**Written Representation to A303 Stonehenge Development Consent Order Examination Process
UR A303-AFP058**

I write on behalf of The Warden or Rector and Scholars of the College in the Blessed Mary and All Saints Lincoln in the University of Oxford of Oxford, OX1 3DR (Lincoln College) in relation to land within their ownership affected by the above scheme Title Numbers WT1249 and WT125102.

The scheme affects land to the south of the A303 known as Earl's Farm Down. The land is let to Mr Charlie Rowland. I understand Mr Rowland is making a similar representation.

**LAND PLANS  
REGULATION 5(2)(i)  
SHEET 9 OF 15**

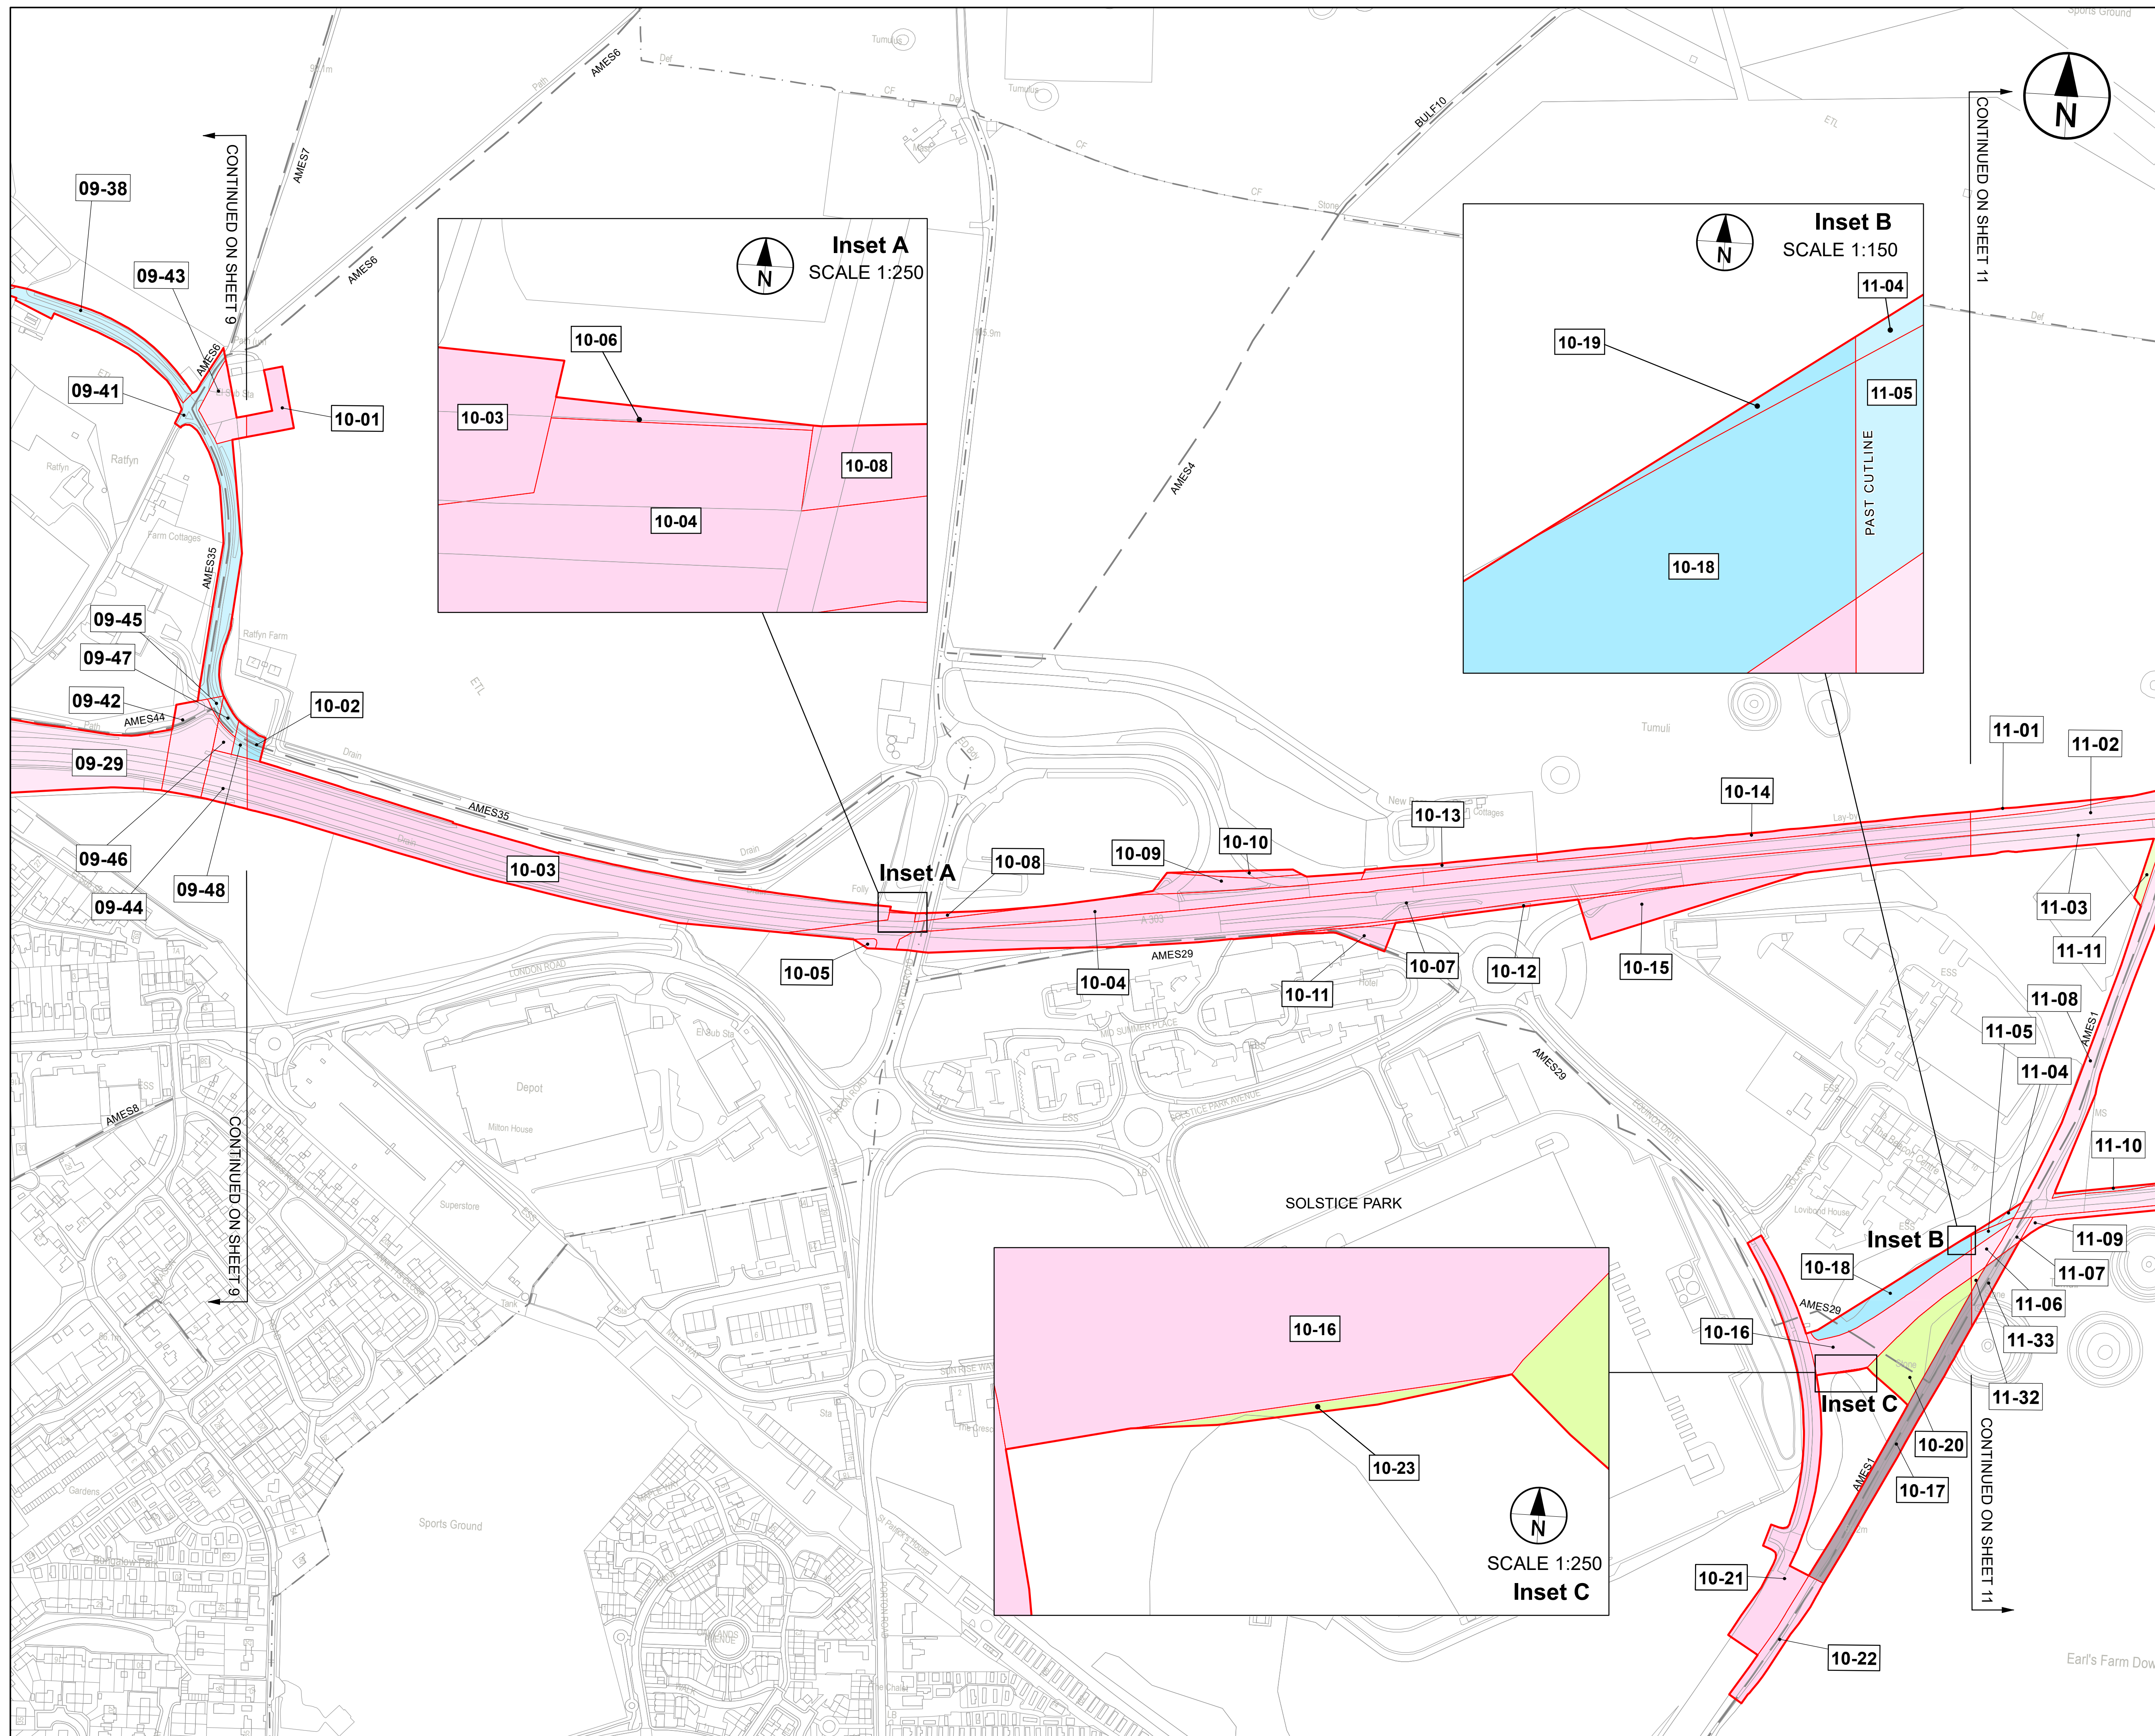
4. TR010025-000157-2-2-LandPlans - LAND PLANS REGULATION 5(2)(i) SHEET 9 OF 15

4.2. 09-30 Permanent acquisition of land - All interests and rights in land comprising of approximately 4823 square metres of field, agricultural land and access track (Ratfyn Farm) (excluding all interests

of the Crown). We are unsure why this area of land is to be acquired rather than the acquisition of rights? This area is currently part of title number WT1249 owned by Lincoln College provides access between the WT23365 owned by THE SECRETARY OF STATE FOR DEFENCE and WT7350 owned by SOUTHERN ELECTRIC POWER DISTRIBUTION PLC. Its acquisition would potentially prevent access to the river and the associated businesses which use it. It would be preferable to grant rights similar to those sought in Plot Ref. 09-27. Plot 09-30 also seeks to acquire the existing access for the sewage treatment plan coloured green below;

If this were successful we would seek rights of access over this area as are currently enjoyed to access retained land

- 4.3. 09-43 Permanent acquisition of land - All interests and rights in land comprising of approximately 1436 square metres of field and agricultural land and hardstanding (Ratfyn Farm) (excluding all interests of the Crown). The purpose of this acquisition has not been made clear and unlike 10-01 which seems a logical extension of the substation, 09-43 seeks to acquire a part of a yard used for machinery but also brings the substation unnecessarily close to Ratfyn House and Ratfyn Farm Cottages. To reduce impact and visibility 10-01 could be enlarged to accommodate the same area and lessen the impact and likely acquisition cost.

- 4.4. 09-42 and 09-46 - Permanent acquisition of land - All interests, save for all interests of Highways England, in land comprising of approximately 319 square metres of woodland (north of A303). We are currently making investigations into the ownership of these parcels as it is not clear how they came to be in the ownership of Highways England Company and whether they should have reverted to Lincoln College. This is an observation and not a point of objection.
